Consultee Comment for planning application 21/04166/F

SKETCHED VIEW FROM STREET THROUGH BURDROP

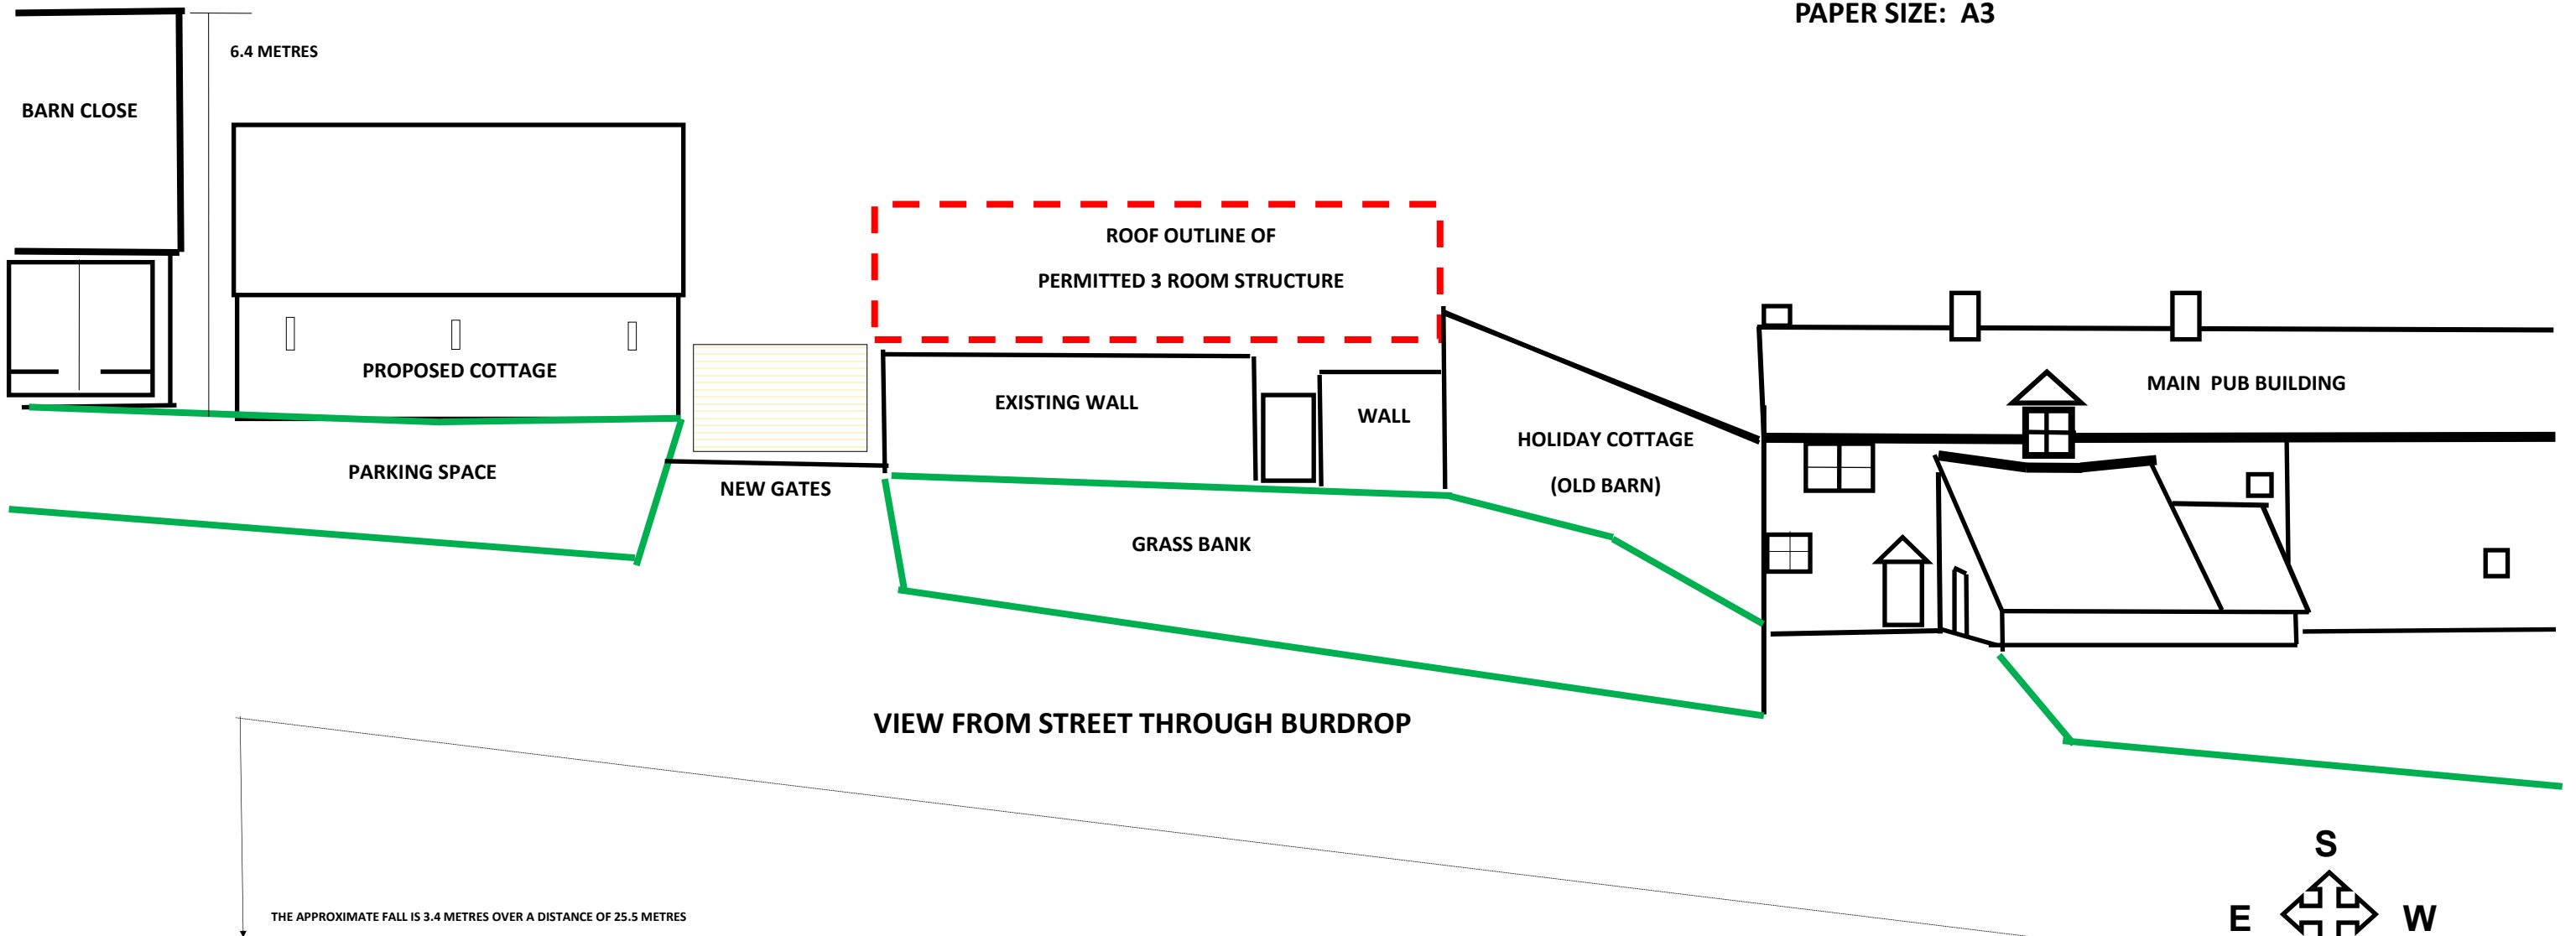
Proposed Cottage? (p4), rather than an Amendment (p5). Design ? the proposed design does not appropriately reflect the photographic evidence provided to support the relocation and is not complementary to this location, thereby having a negative impact on the identified street scene in this sensitive conservation area Materials ? the photographic evidence clearly identifies local stone and thatch, which has been retained for the existing neighbouring barn. A similar use of materials would complement the adjacent Grade 2 listed building, generating a positive impact on the street scene in this sensitive conservation area. No specific details are included for doors, windows, rainwater goods Conditions: The scope and detail identified in the APP Schedule of Conditions (p5) continue to be appropriate and relevant for any building in this location.
